HERTFORDSHIRE BIOLOGICAL RECORDS CENTRE

Plask for:- G Goodall
Our Ref :-
Your Ref :- S6/2009/2273/FP
Tel :- 01992 556155

**Planning Application: S6/2009/2273/FP; Vine Cottage, Well Road, Cuffley.
Erection of two storey side extension, rear extension, new front dormer and replacement front porch; new outbuilding following demolition of existing outbuilding.**

PROPOSED GARAGE LAYOUT

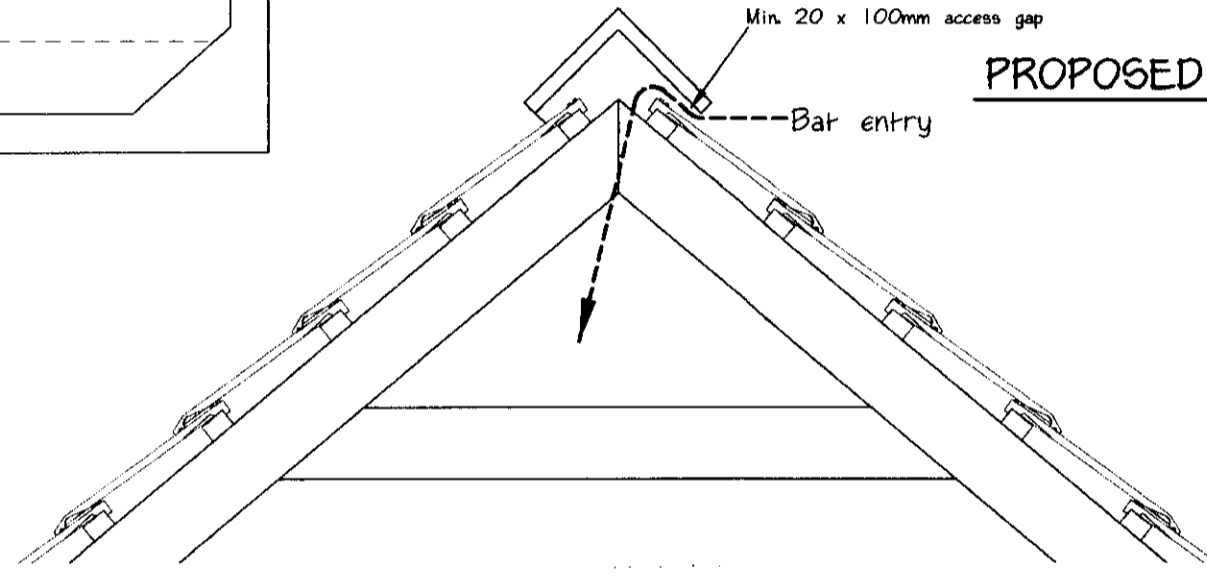
Four Woodcrete Schwegler bat boxes Type 1FF and 2F will be placed on mature trees in the garden of the house. These will offer additional roost sites for bats. In addition, a replacement roost site will be constructed in the roof space of the proposed double garage, to be built prior to the dismantling of the existing roost sites.

1. The mitigation strategy, including the licence application, must be instigated, in full, under the personal supervision of the bat consultants.
2. A replacement roost site will be constructed in the roof space of the proposed double garage, prior to the dismantling of the existing roost sites.

7. Additional crevice roosting sites will be created around the exterior of the double garage.
8. There will be no direct lighting on the bat roosting area, particularly roost access and exit points.

PROPOSED ELEVATIONS - 1:100

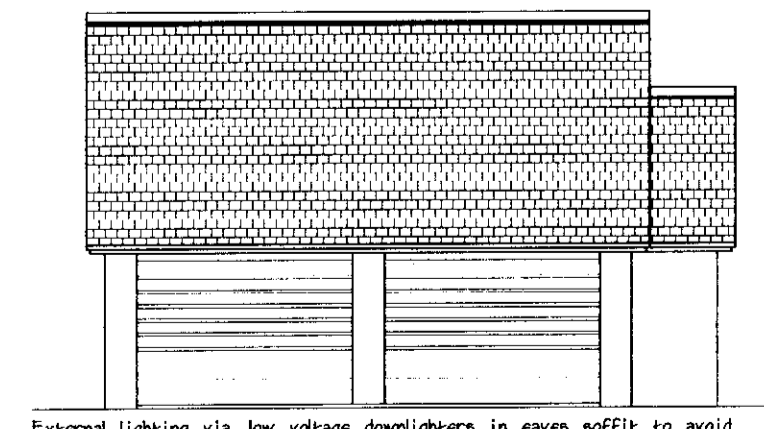
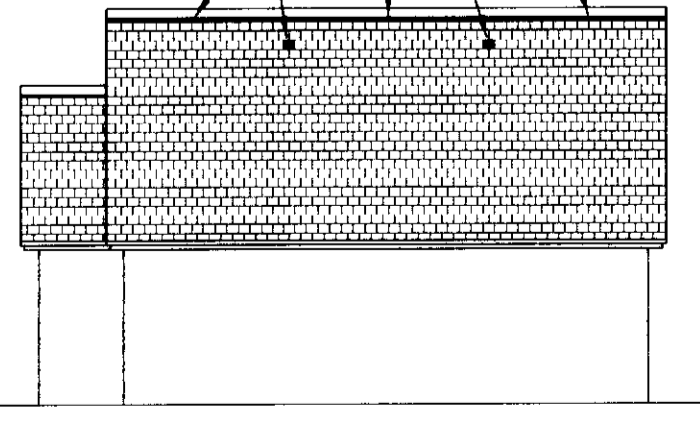
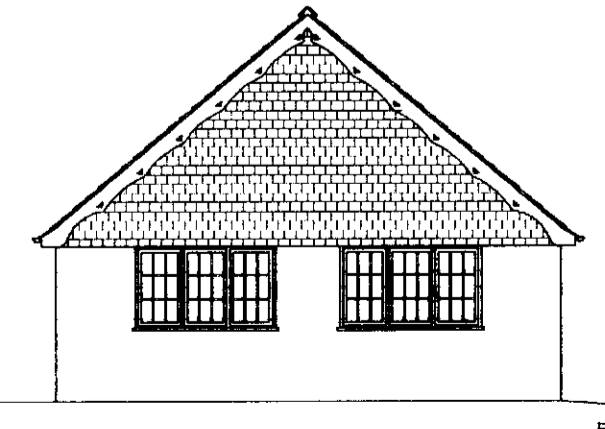
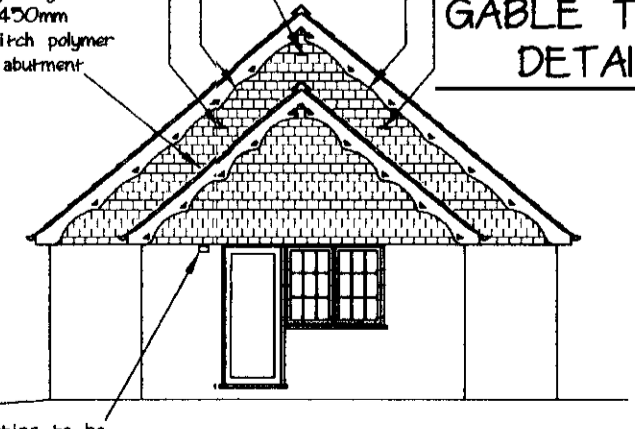
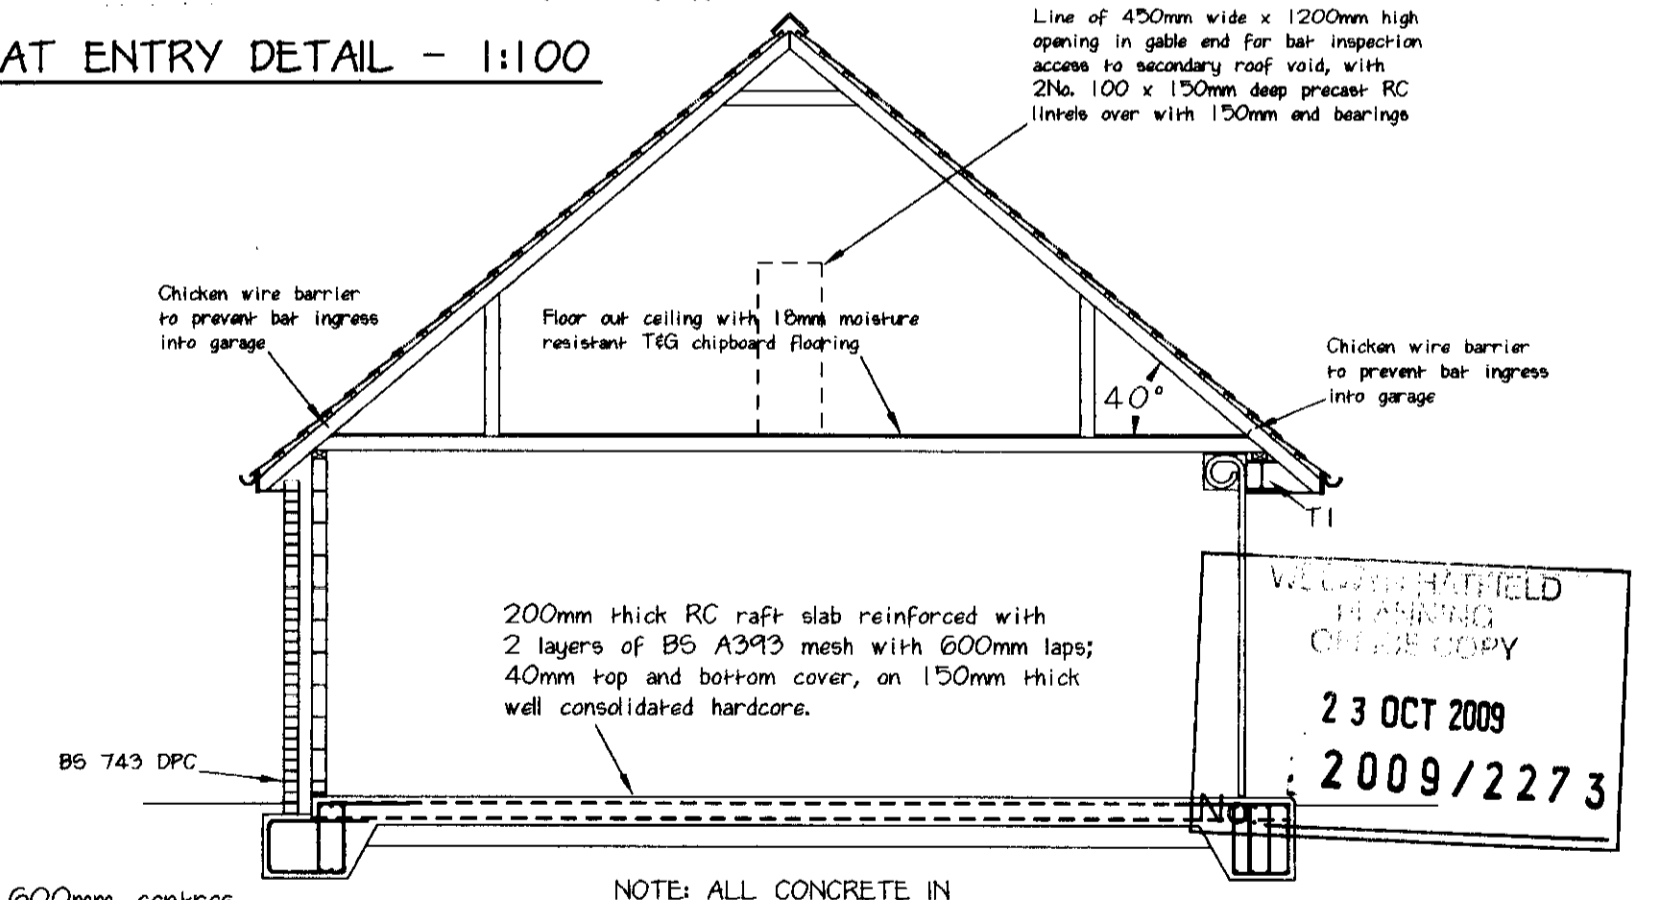
3. The proposed new roof space will create new roost sites for bats.
4. New access and entry points for bats will be created in the new roof of the house and the double garage.
